Sent: 07 July 2017 08:23
To: Richard Temple
Subject: Fwd: BR/162/17/HH

I live at no 15 Newhall Close directly next to the premises subject to the above planning application which replaces an earlier version that was withdrawn. Although at this stage I do not wish to make a formal comment about the application I wondered if you were able to clarify a couple of points.

FIRST FLOOR
PLAN

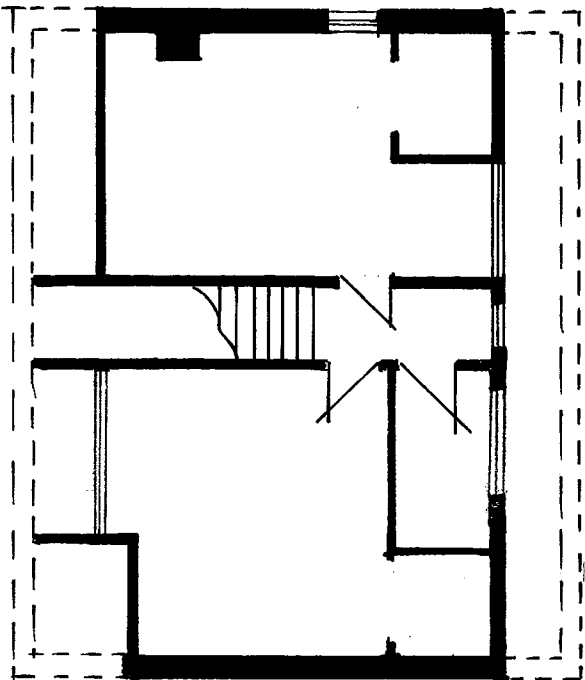
In the revised plans Bedroom 3 does not appear to have any windows in it is that possible?

Bedroom 4 which appears to be about 9m x 5m seems to only have a small window at the northern end if I am reading the plans correctly.

My concern is that perhaps the plans submitted do not show how the building will actually look. Can you confirm that Velux type windows do not require planning permission just compliance with building regulations? I fear that to give light to these rooms and perhaps Bedroom 1 as well Velux windows will be fitted wherever the applicant wishes.

Is it possible that this could occur and if it is the applicants intention to put those openings in should they not be shown on the application?
